RE: Application for Single Family Residences, Ruby Lane lots #1, 2, and 17

Upon review of the site plans, the City's Planning Division has the following comments:

Lot #2: This application is un-approvable for the following reasons:

LOT 2 LAYOUT & UTILITIES PLAN

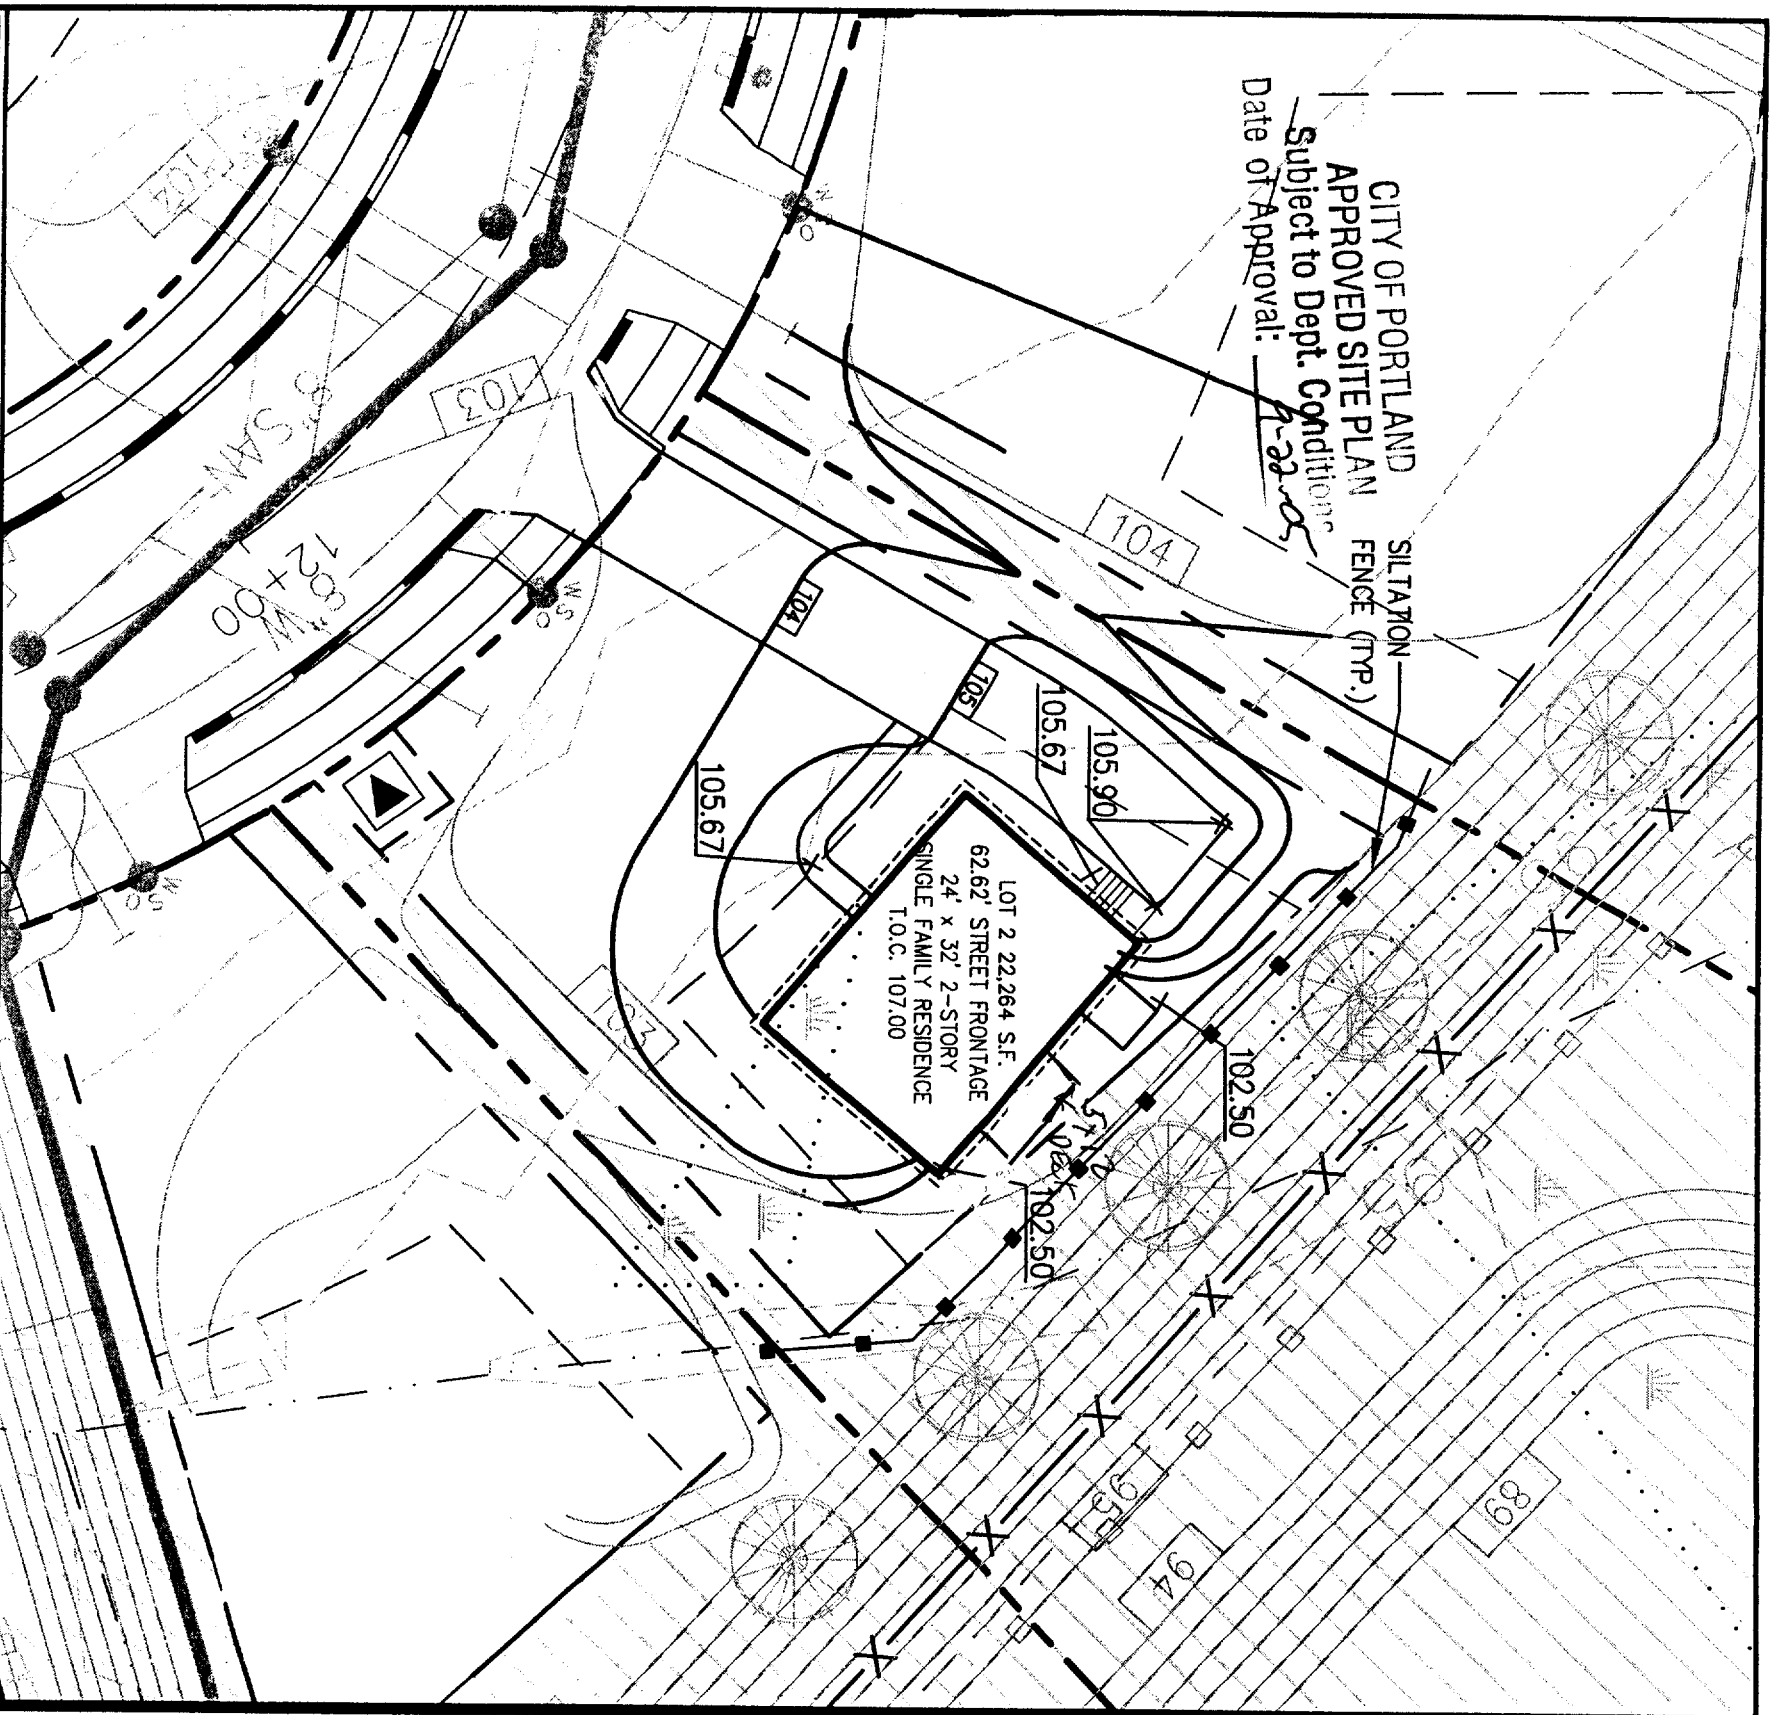
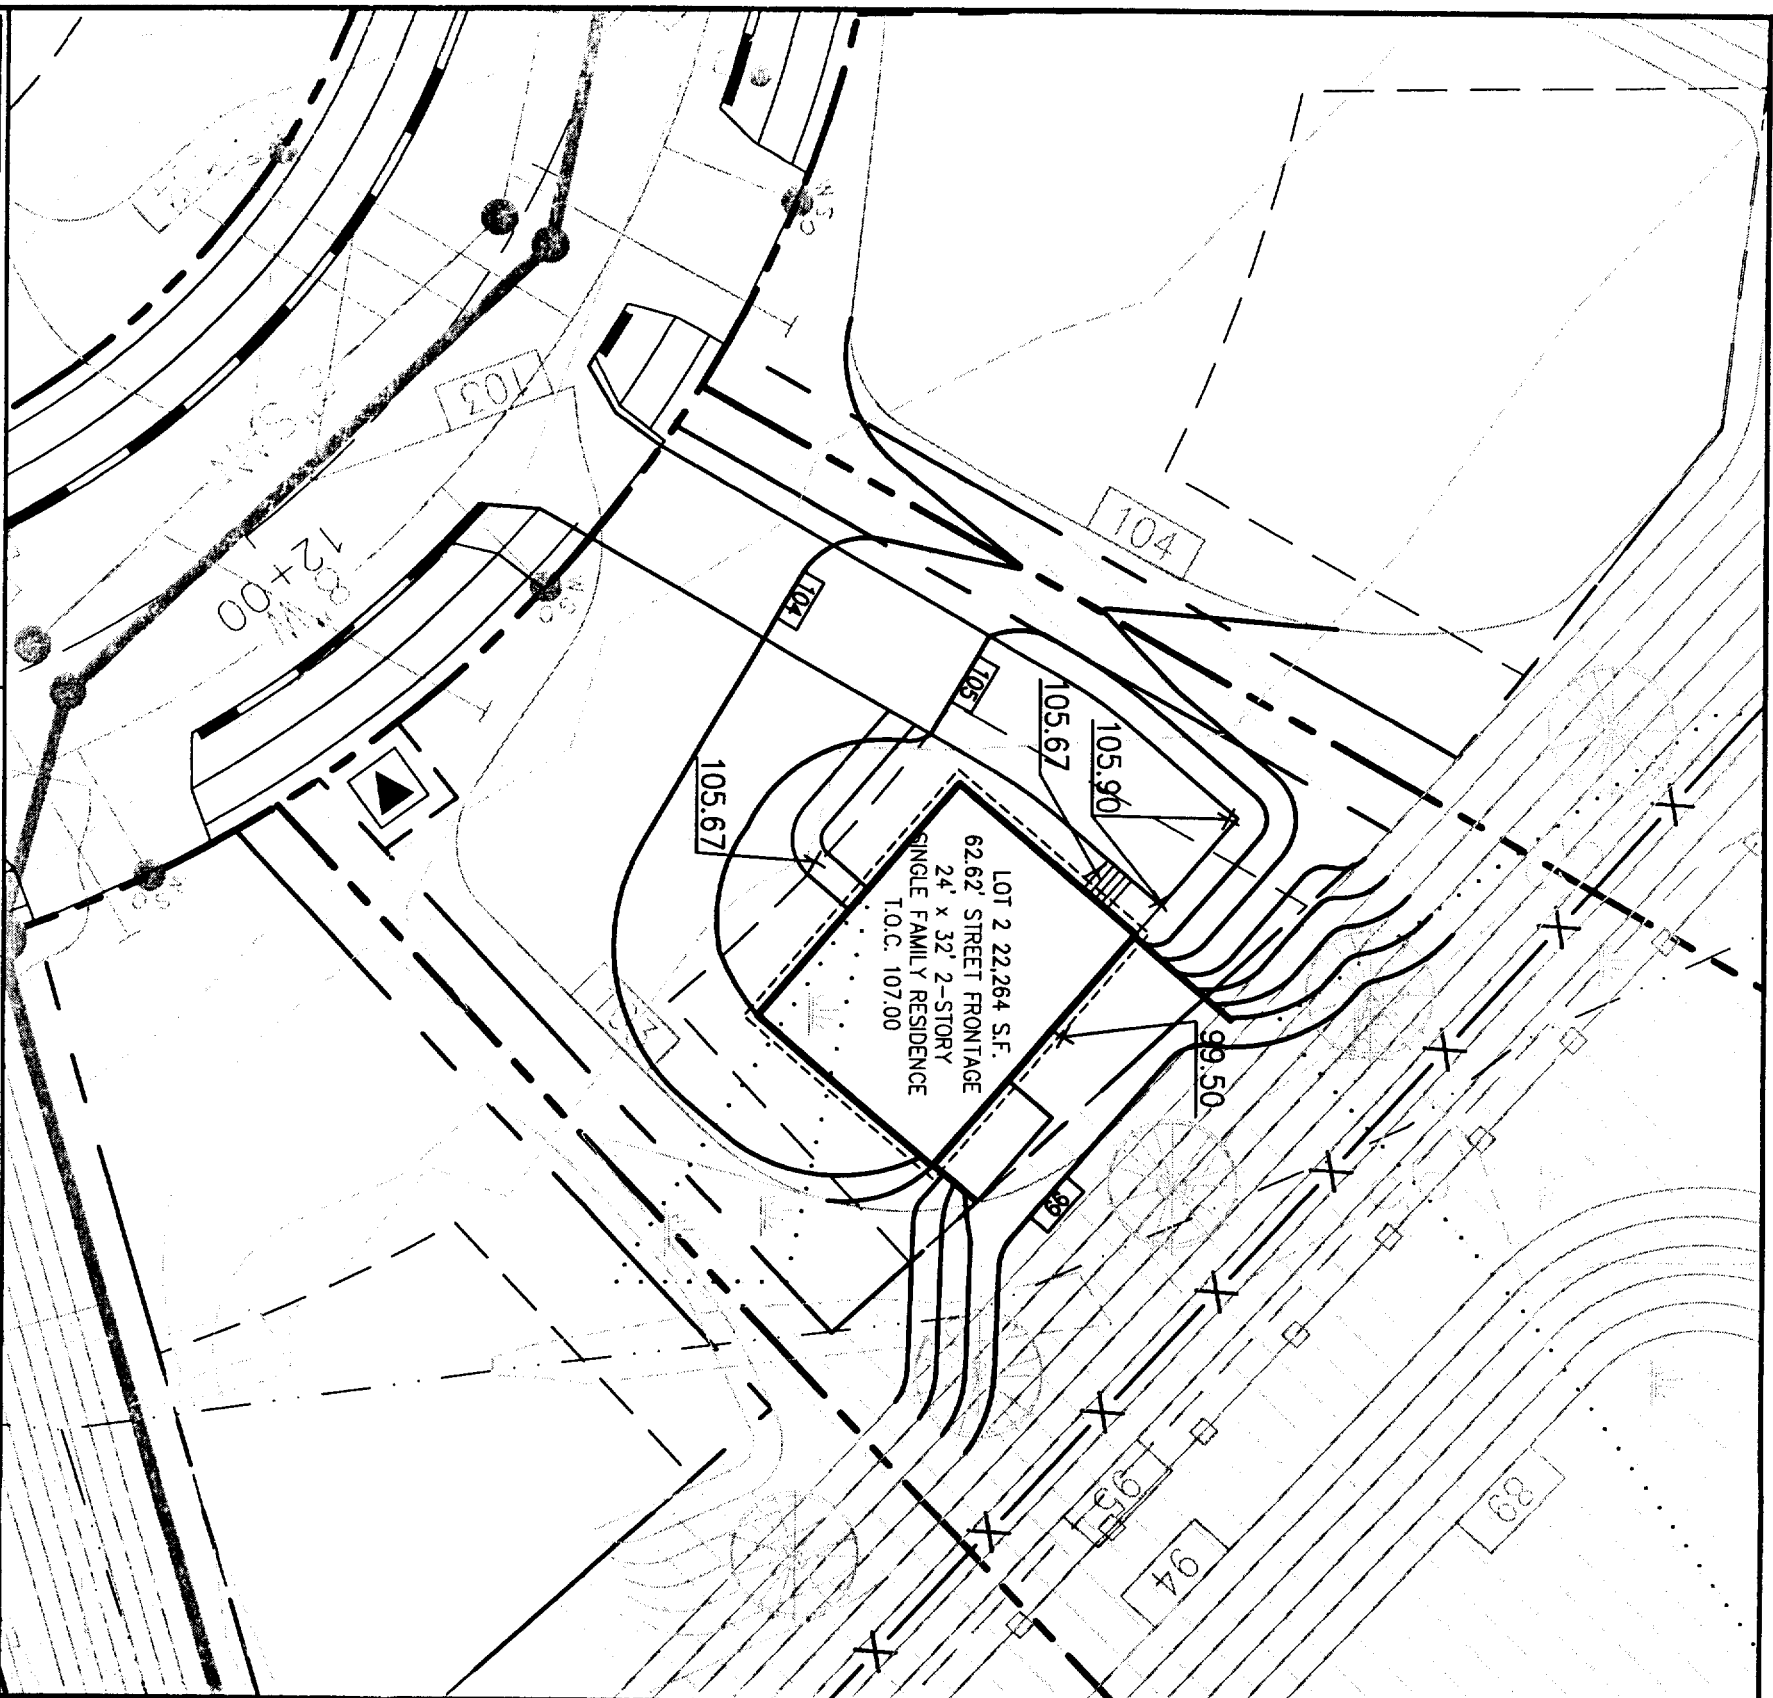
1. Same as items #1, 2, 3, and 4 above.
2. The other retaining wall and deck appear to end along this easement line. There should be some separation between the buildout of the deck/retaining wall and the easement line to ensure there are no encroachments.
